Your ref:	46 Wimpole Street	<b>Please reply to:</b>	<b>Mr Anthony Perera</b>
Our ref:	23/05923/FULL	Tel No:	07866034072
		Fee Queries:	0207 641 6500;
		Email:	planningreception@westminster.gov.uk;
Mr David Ferns Interieur London Ltd 1Rivington Place Shoreditch London EC2A 3BA United Kingdom		<b>Incomplete Applications</b> Town Planning & Building Control City of Westminster PO Box 732 Redhill, RH1 9FL	
			6 September 2023

**Address: Flat 2, 46 Wimpole Street, London, W1G 8SD,**

**Proposal: Reconfiguration of a two bedroom, one bathroom apartment, including internal alterations, removal of structural walls and replacement of timber sash windows.**

FRONT AND REAR ELEVATIONS

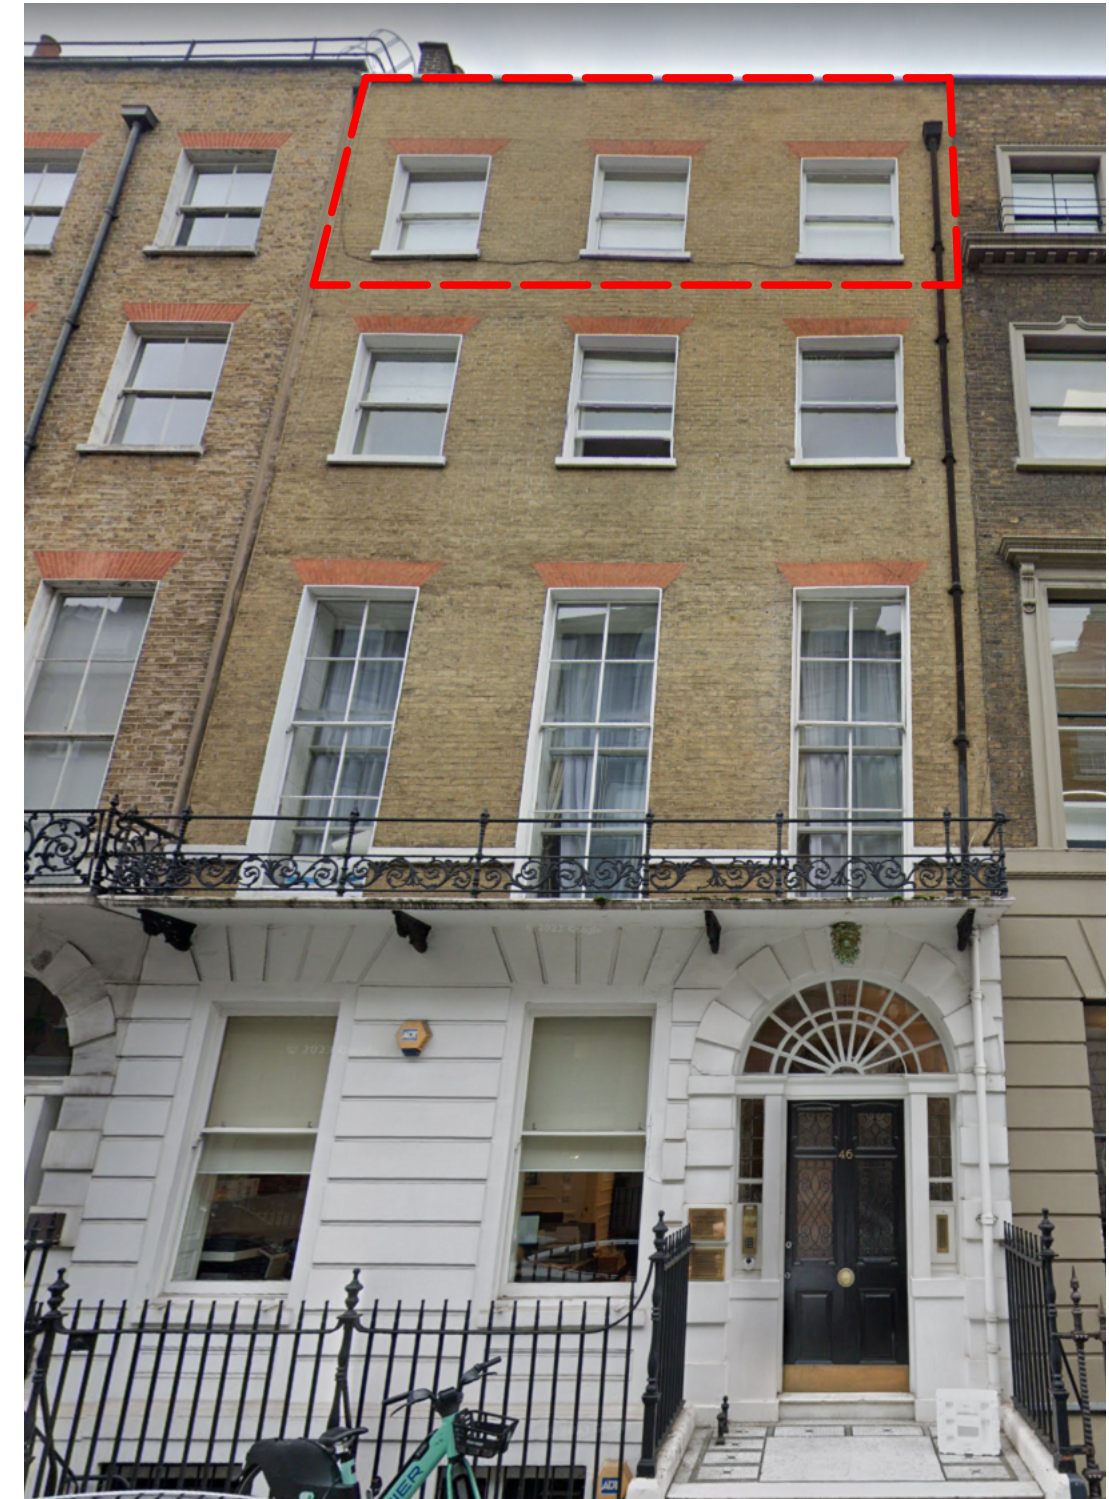
- 4 Please provide manufacturers specification of the replacement windows to include details of the proposed materials. Please provide an annotated elevation or photo cross referenced to show the location of the window/s to be replaced in the context of the whole building.
